Harnett County
420 McKinney Pkwy

12/13/2023

SUBJECT: SFD2306-0058
SINGLE FAMILY DWELLING

Here are the results of all Inspections located at **794 COBB RD:**

WEST POINT AMERICAN TRADITION / CUSTOM
 FIRST FLOOR JOIST PLAN

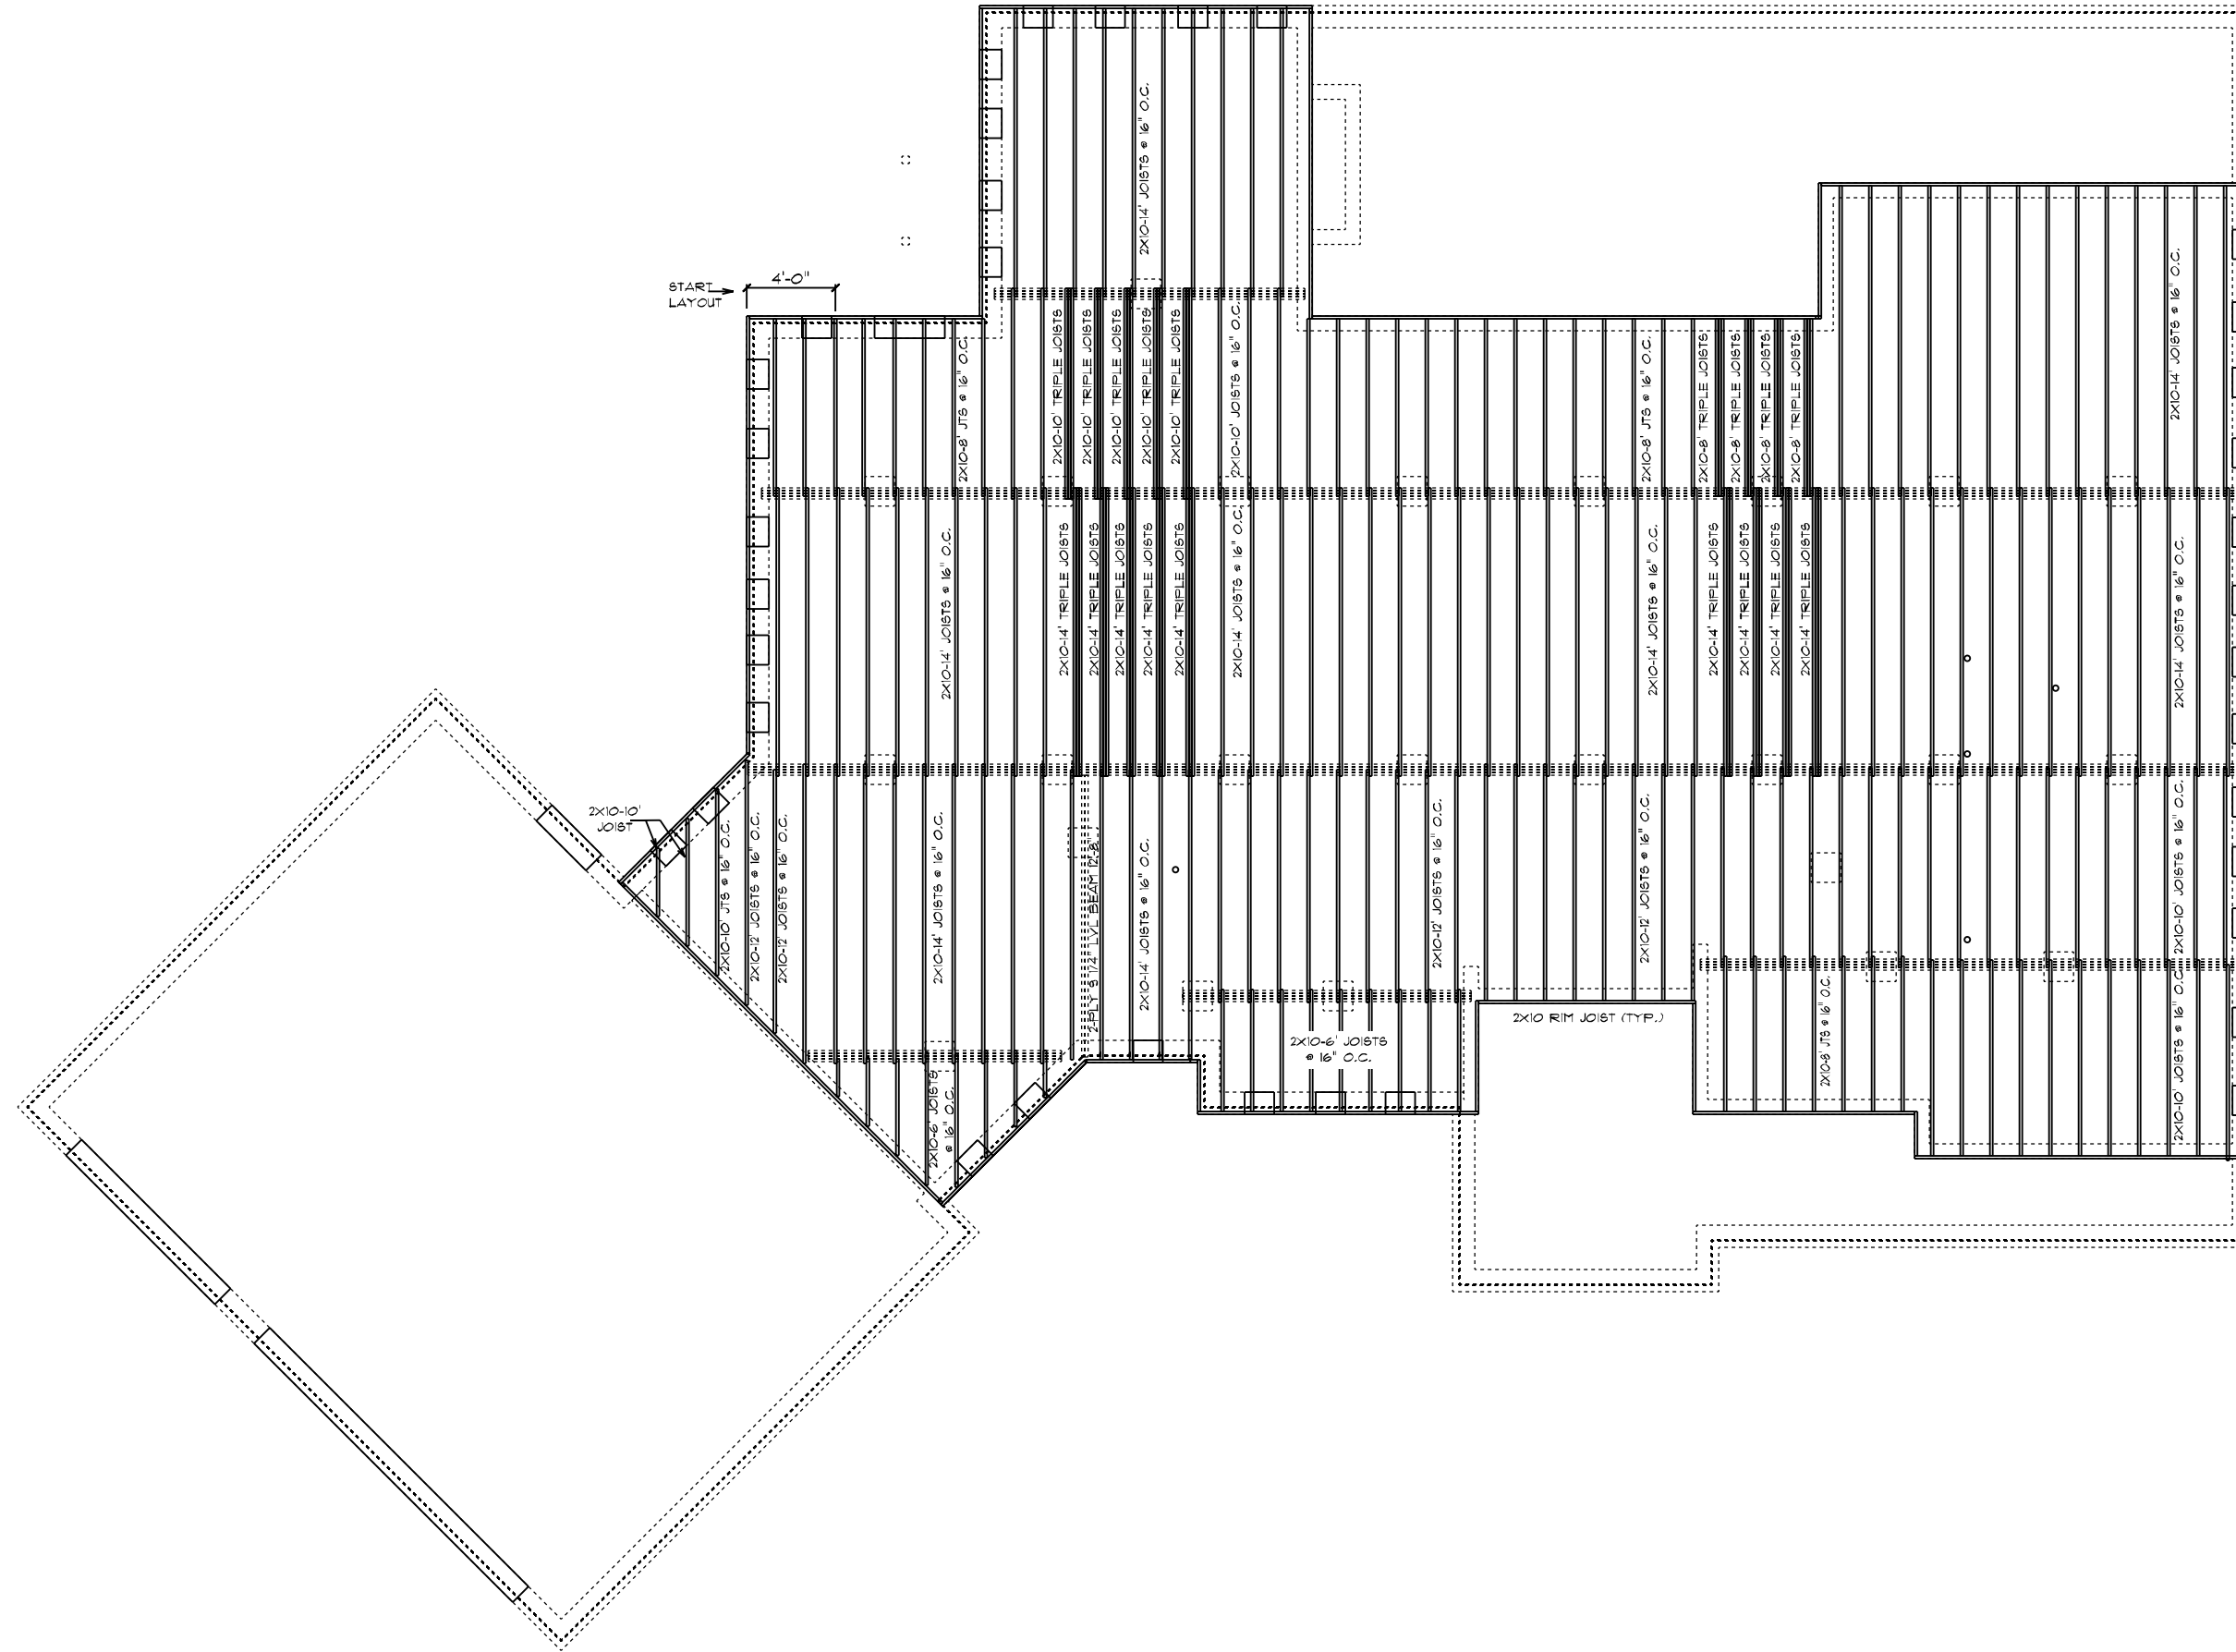
All 3ply floor joists need to be nailed per code All 4 ply girders need to be bolted per code
